Application No: BN/16/22/PL
Site Address: Land to the rear of Clare Court 67 Barnham Road Eastergate PO22 0EP
Description of works: Erection of 4 No dwellings with associated car parking. This application is in CIL Zone 2 and is CIL Liable as new dwellings.

YET MORE MISREPRESENTATIONS - STREET SCENE and DESIGN

DRWG. No 1474/14
SCALE 1:200 AT A3
© FEB '25th 2022

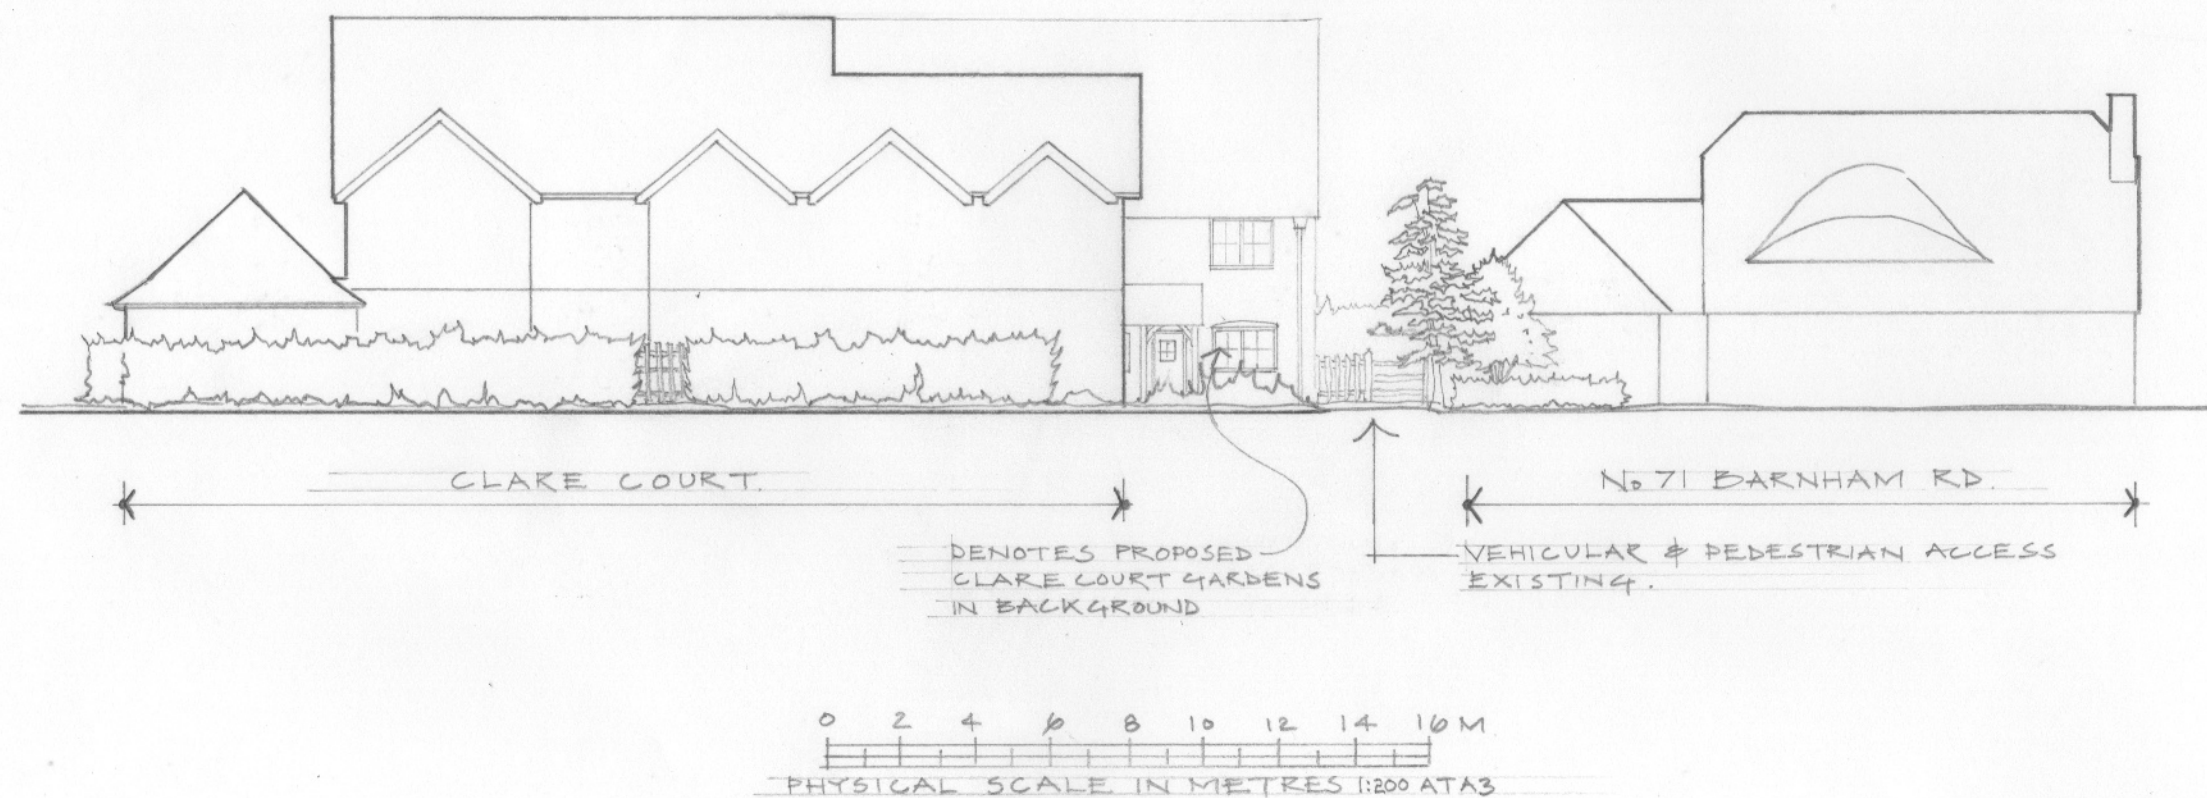
The proposed Street Scene drawing (1474/4) shows that a large portion of House No 1 and much of the roof of the entire first pair of houses, will be visible when viewed from directly opposite the entrance road. But this is far from being the whole story; to present the view from one convenient fixed spot belies the truth of the matter. The view from "the wider area", referred to in the Pre-Application Advice, will include the entire row of houses - and this is what anyone driving or walking along Barnham Road in a southerly direction will see, namely, an EYESORE blighting our Area of Special Character.
